From: Carol Reynolds
Sent: 02 July 2018 10:16
To: Planning.Responses
Subject: FW: Planning Consultation on: A/83/18/RES

APPLICATION A/83/18/RES

Site Address: Land west of Brook Lane and south of A259 Rustington BN16
3JL

Description of Works: Approval of reserved matters following outline approval A/144/17/OUT for access only for the demolition of existing buildings on site & the erection of a mixed use development comprising up to 90 No. residential units & a care home (Use Class C2 & C3) & ancillary facilities, including railway crossing, together with associated access, car parking & landscaping. This application also lies within the parishes of Littlehampton & Rustington.

drawing number
SPRUST(BROOK LANE).1/11

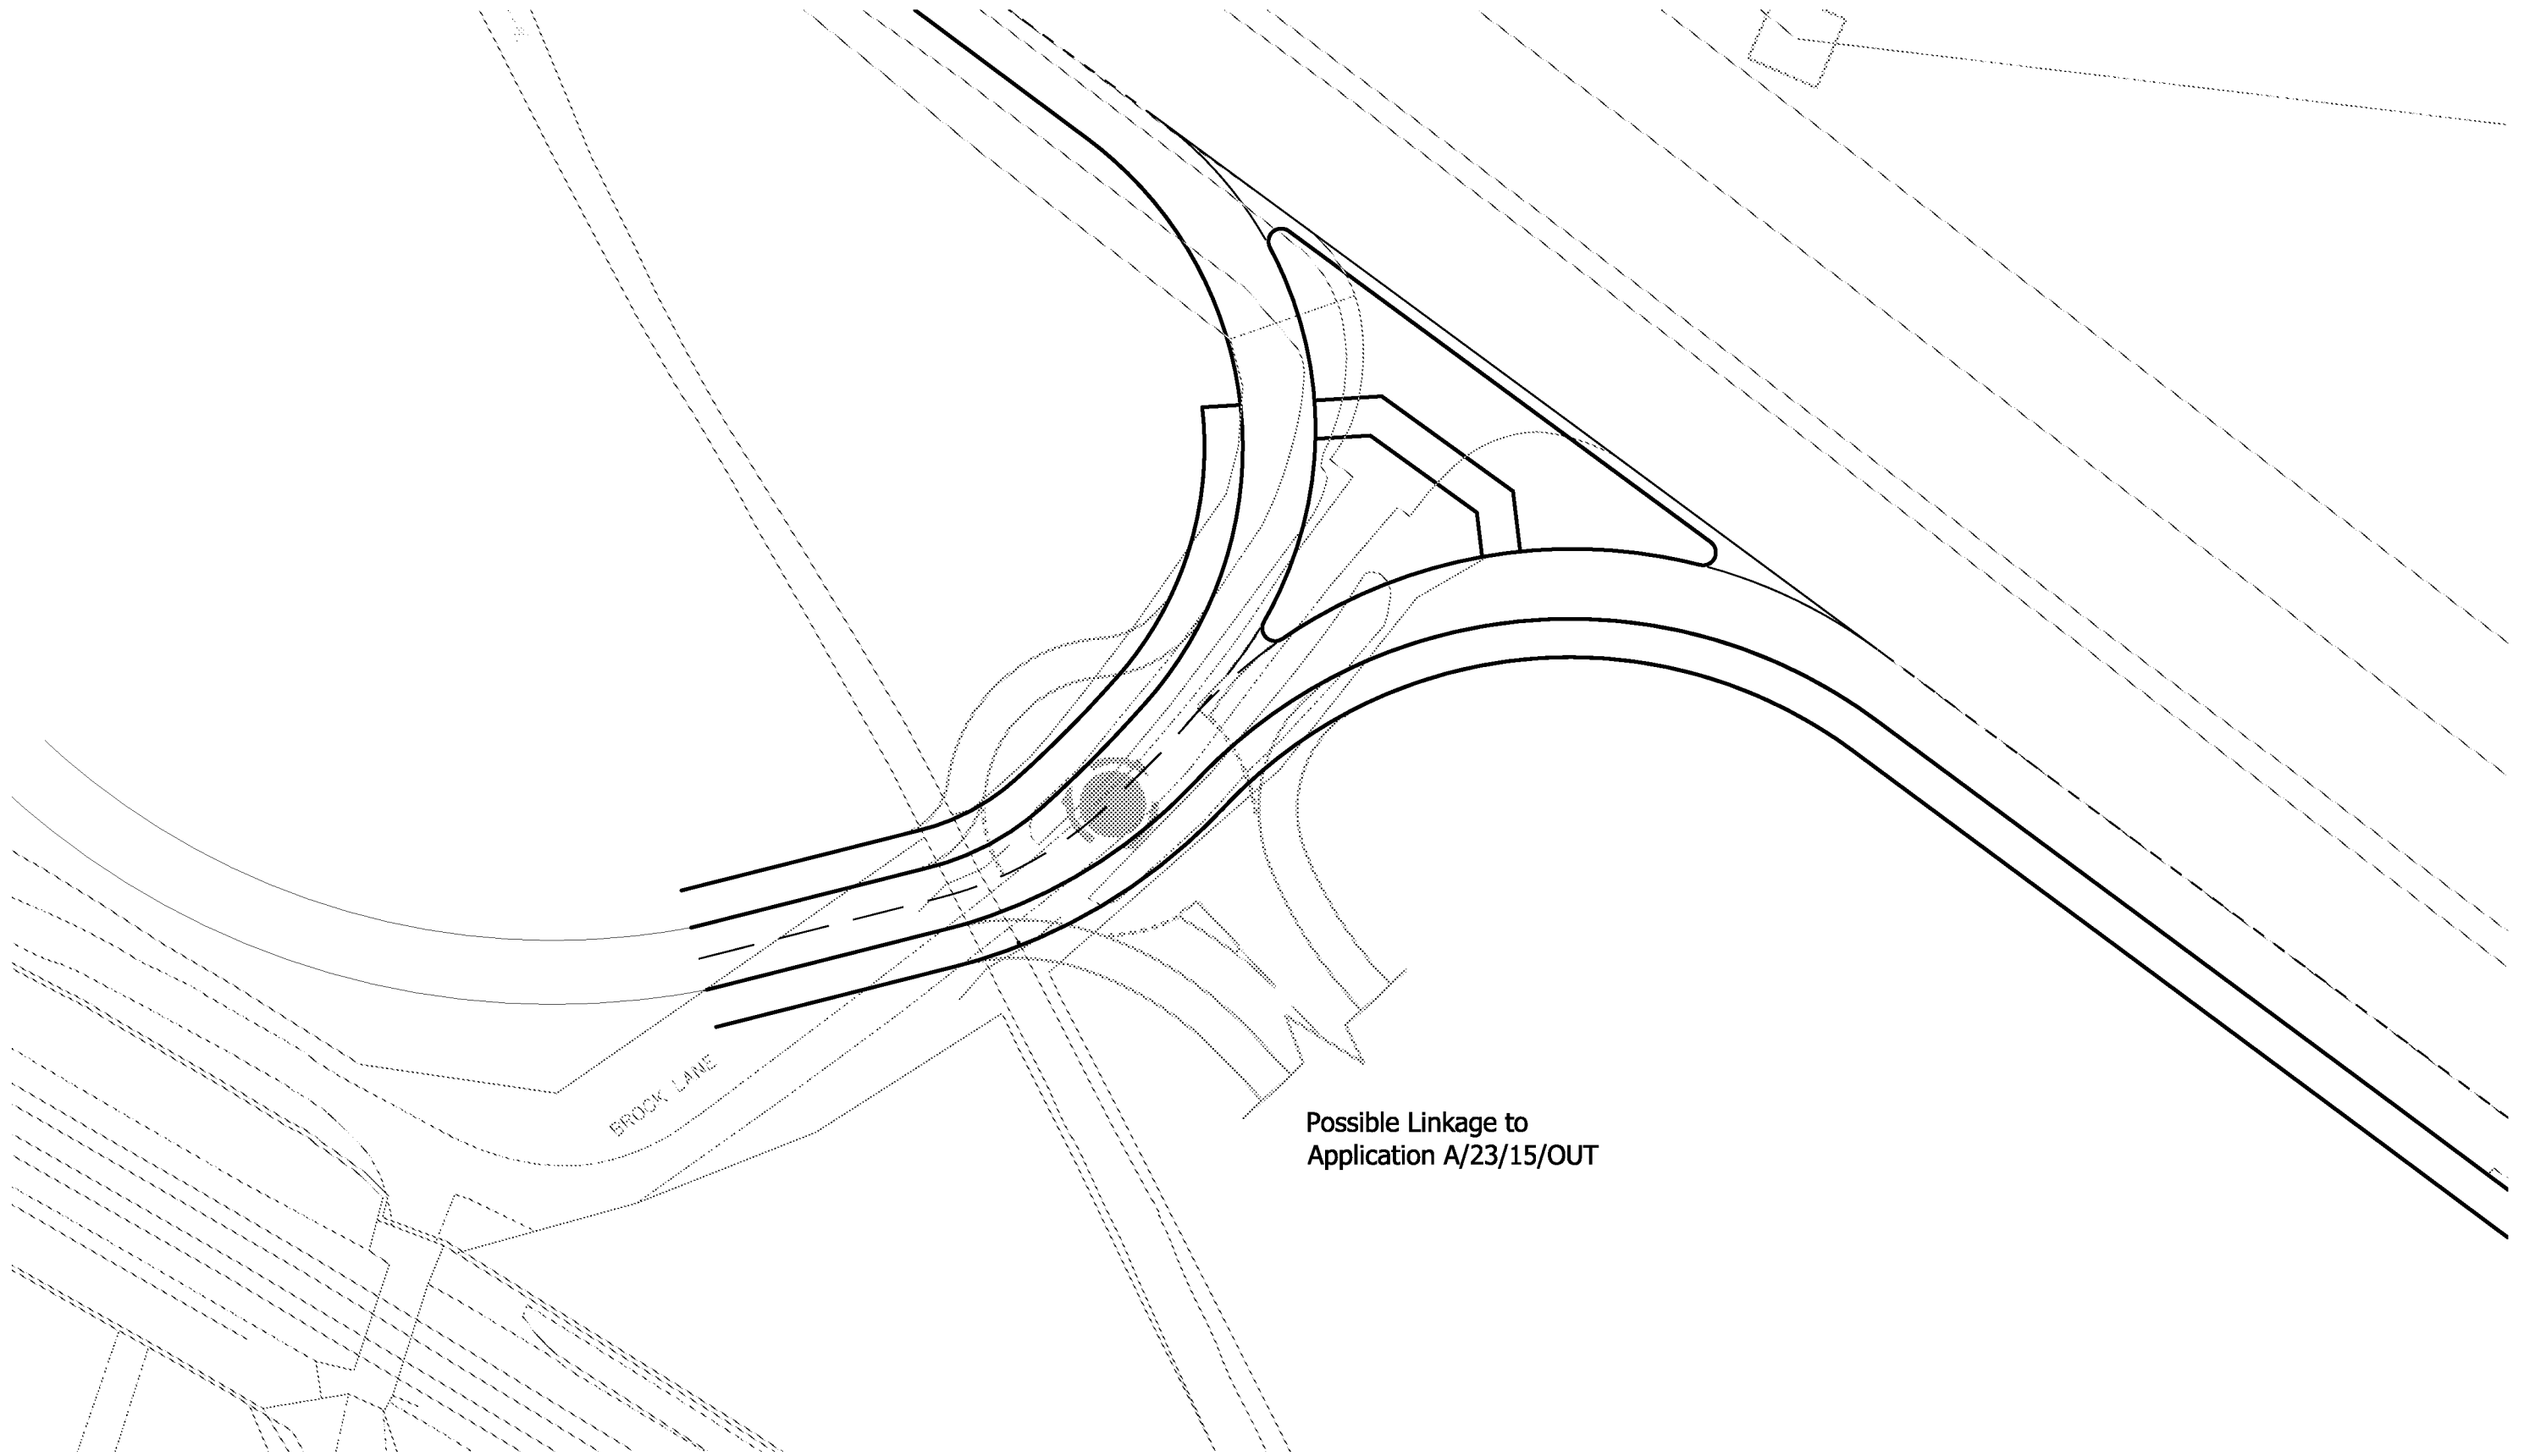
Road noise. This Department awaits notification of the way in which the developer will deal with the adverse effect of road noise on residential units including C2 and C3 use, in 'sensitive receptor' rooms above ground floor level. The significant height of the road above these dwellings indicates that an acoustic barrier of suitable height will be required alongside the A259.
